## POST EPC MEMORANDUM

RE: PR-2022-007851, SI-2022-02075-Buddhist Temple, Site Plan – EPC Major Amendment

**Project # PR-2022-007851**

SI-2022-02075 - Site Plan- Major Amendment

4 SOUTH ELEVATION
SCALE: 1/8" = 1'-0"

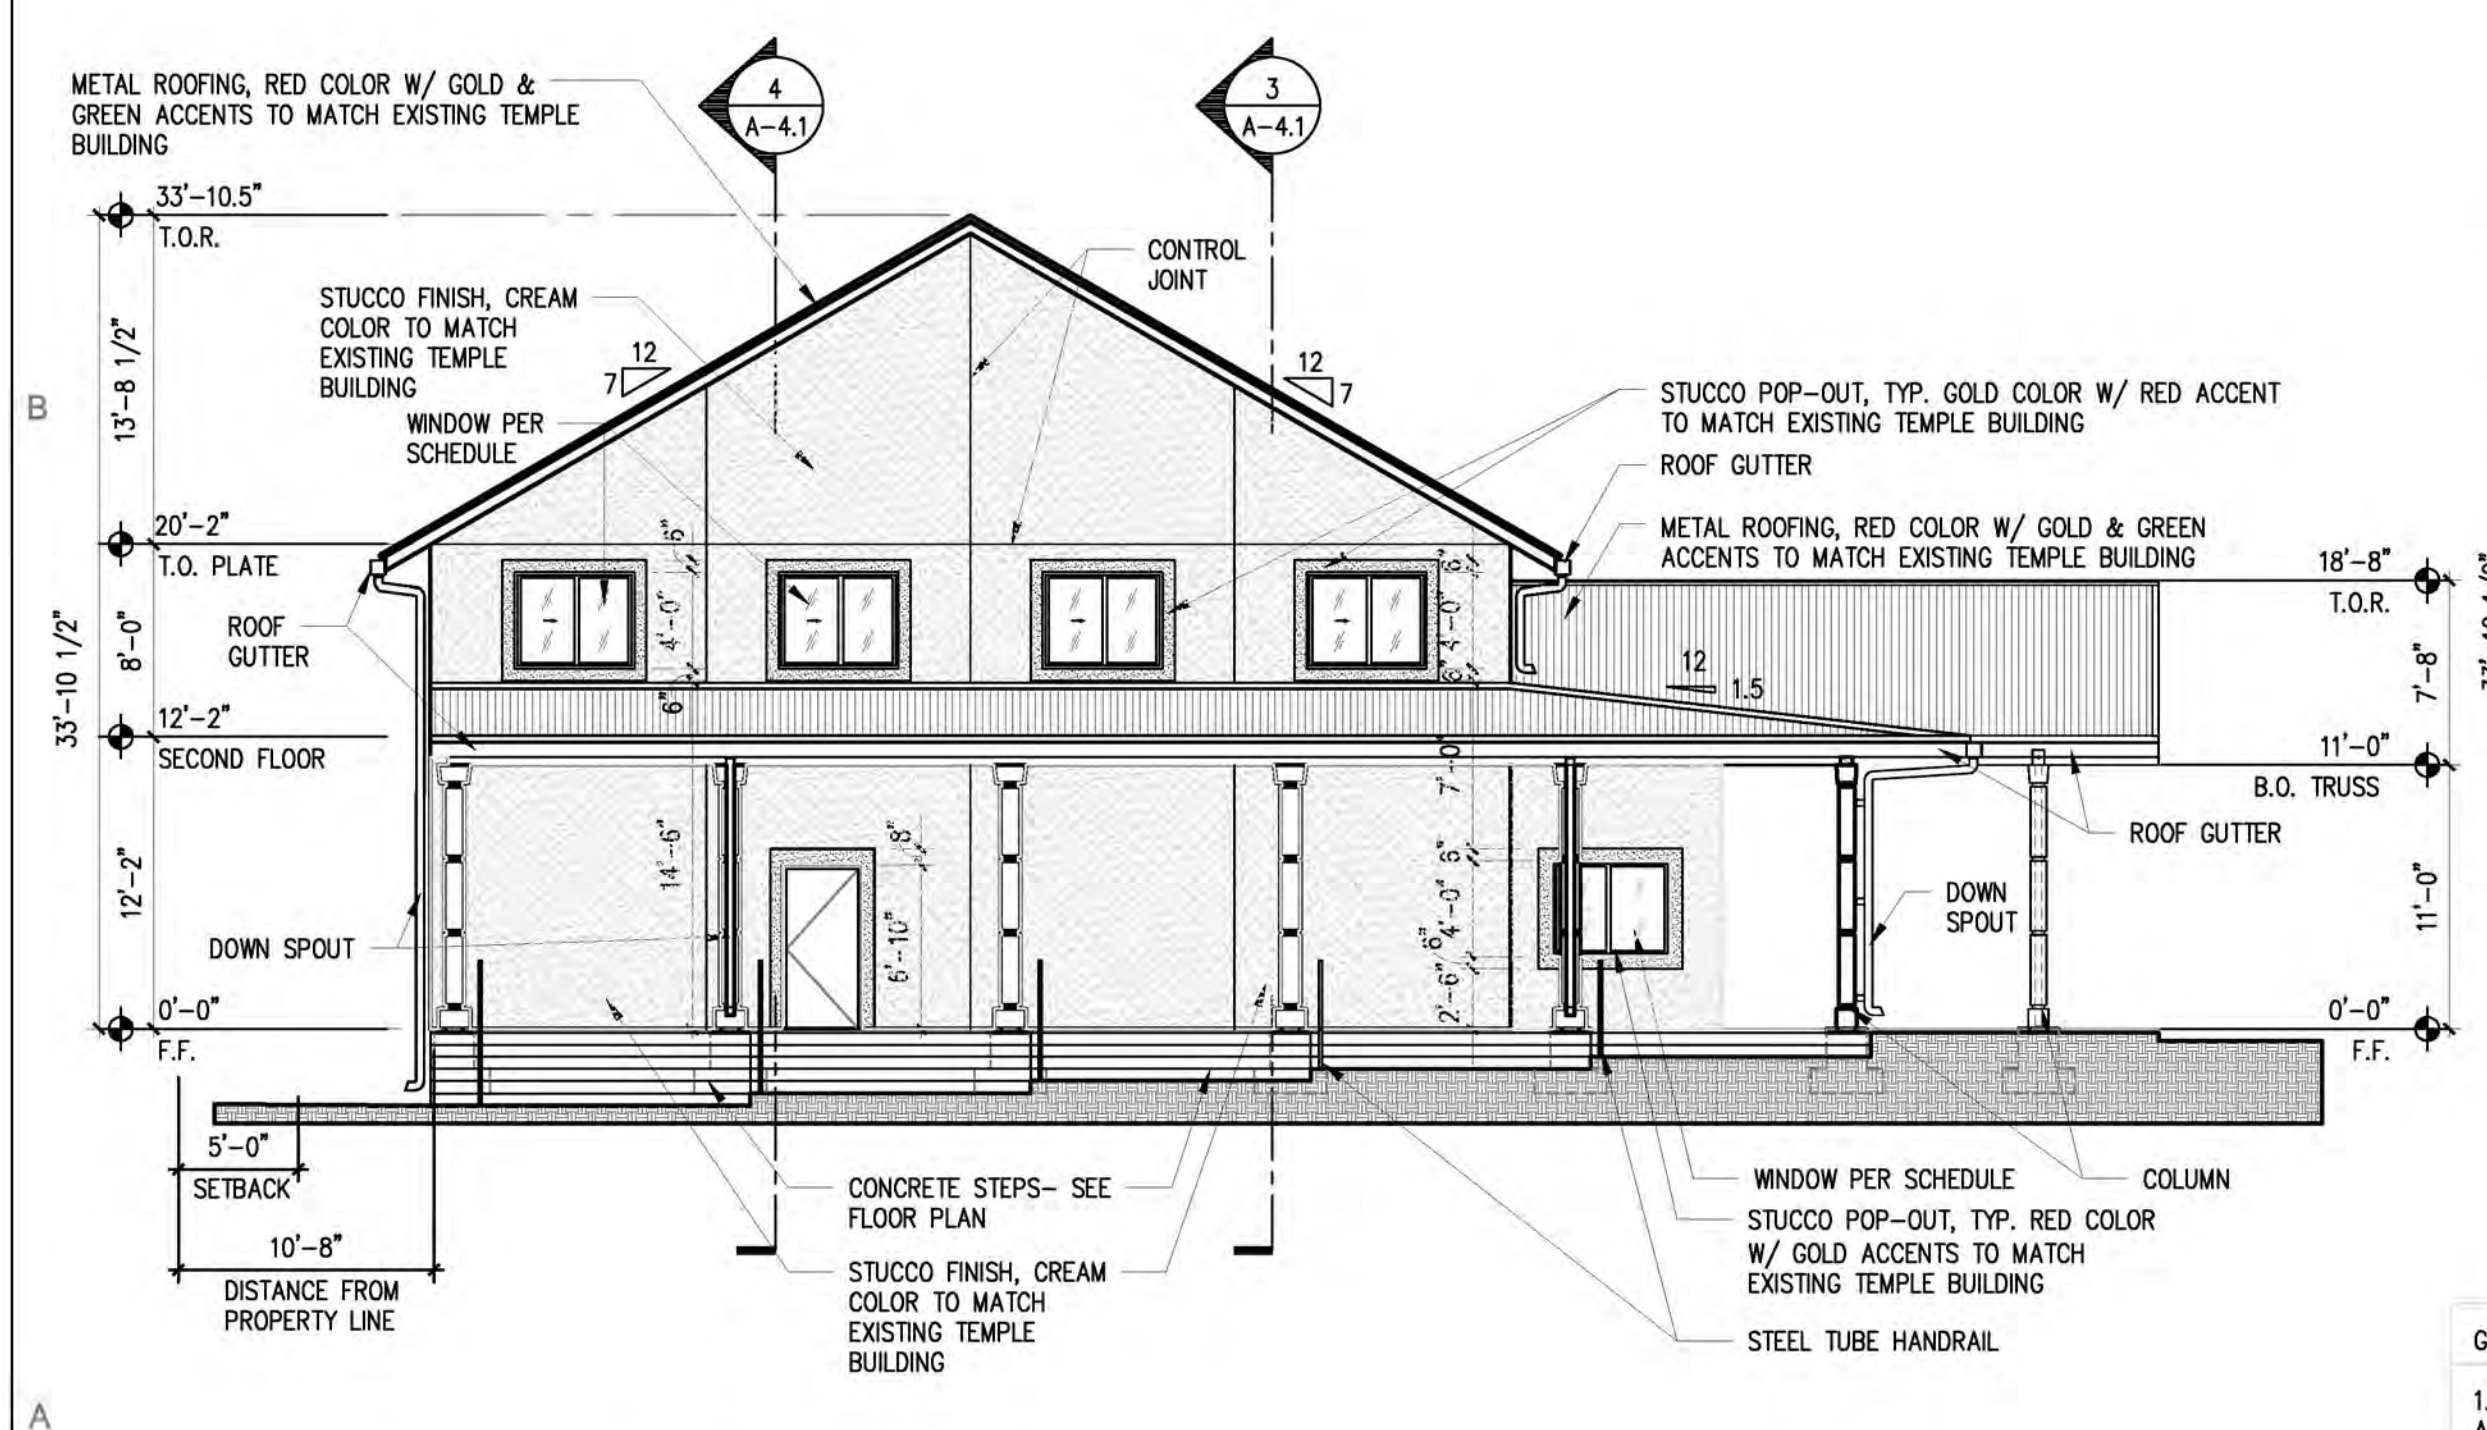
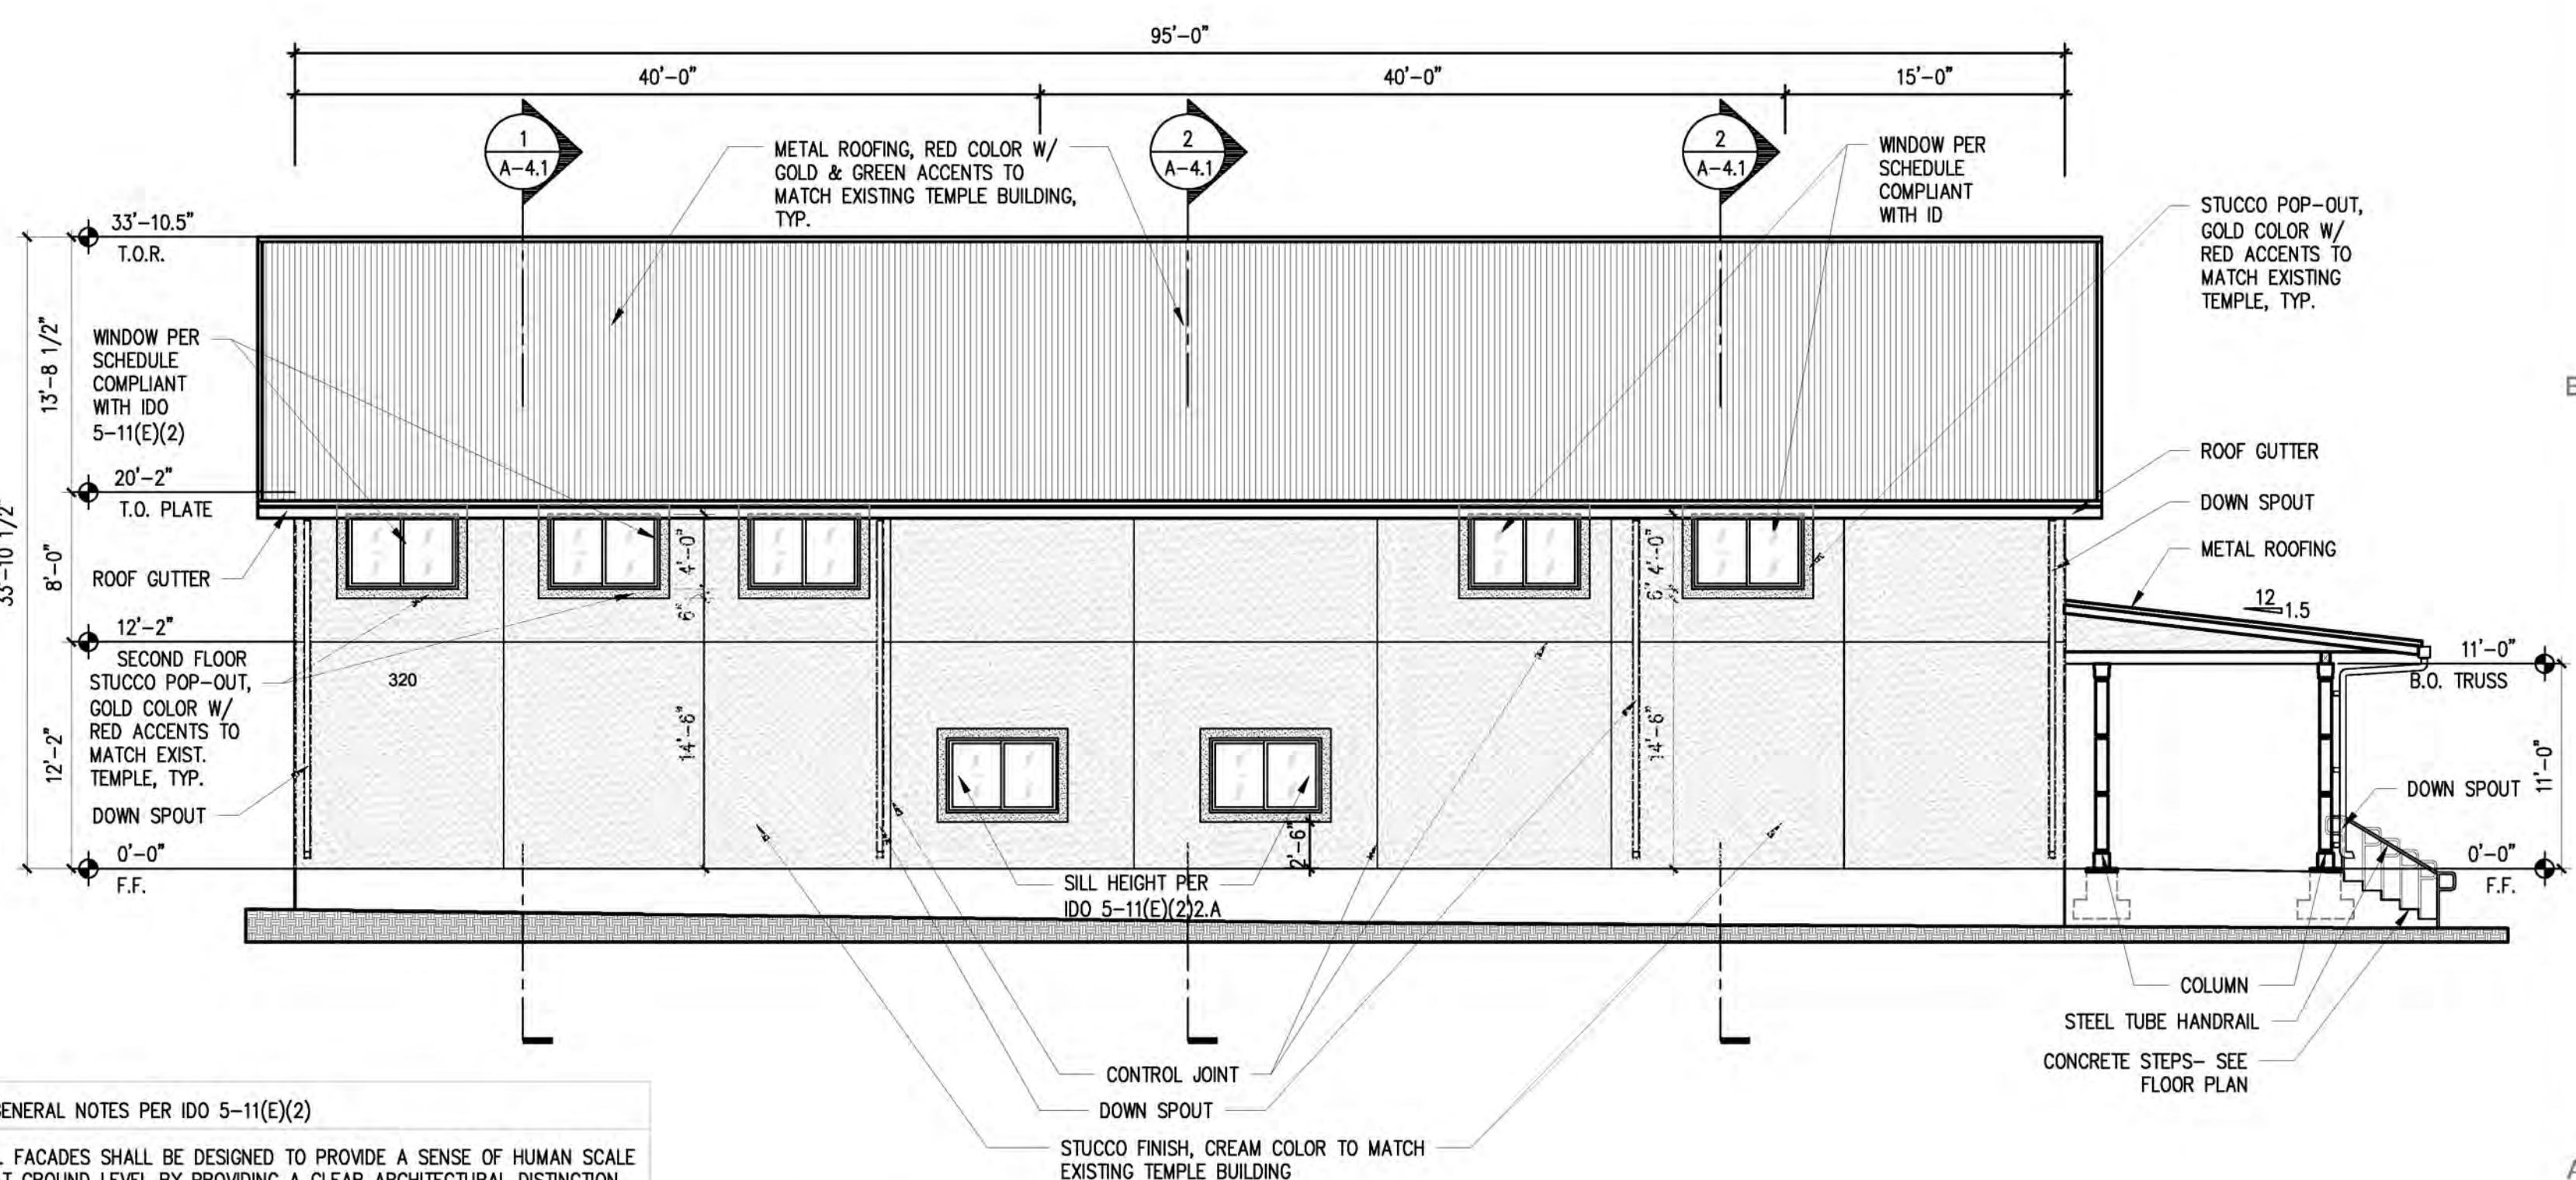
6. **Elevations** shall specify building materials and colors.

The building exterior stucco field colors will be similar to the exterior finishes of the existing Temple building. Cream color stucco for the exterior wall finish, gold color stucco "frames" around building window and door openings with red color accents. There will be a red metal roof panel with eave and soffit trim elements with gold and green color accents.
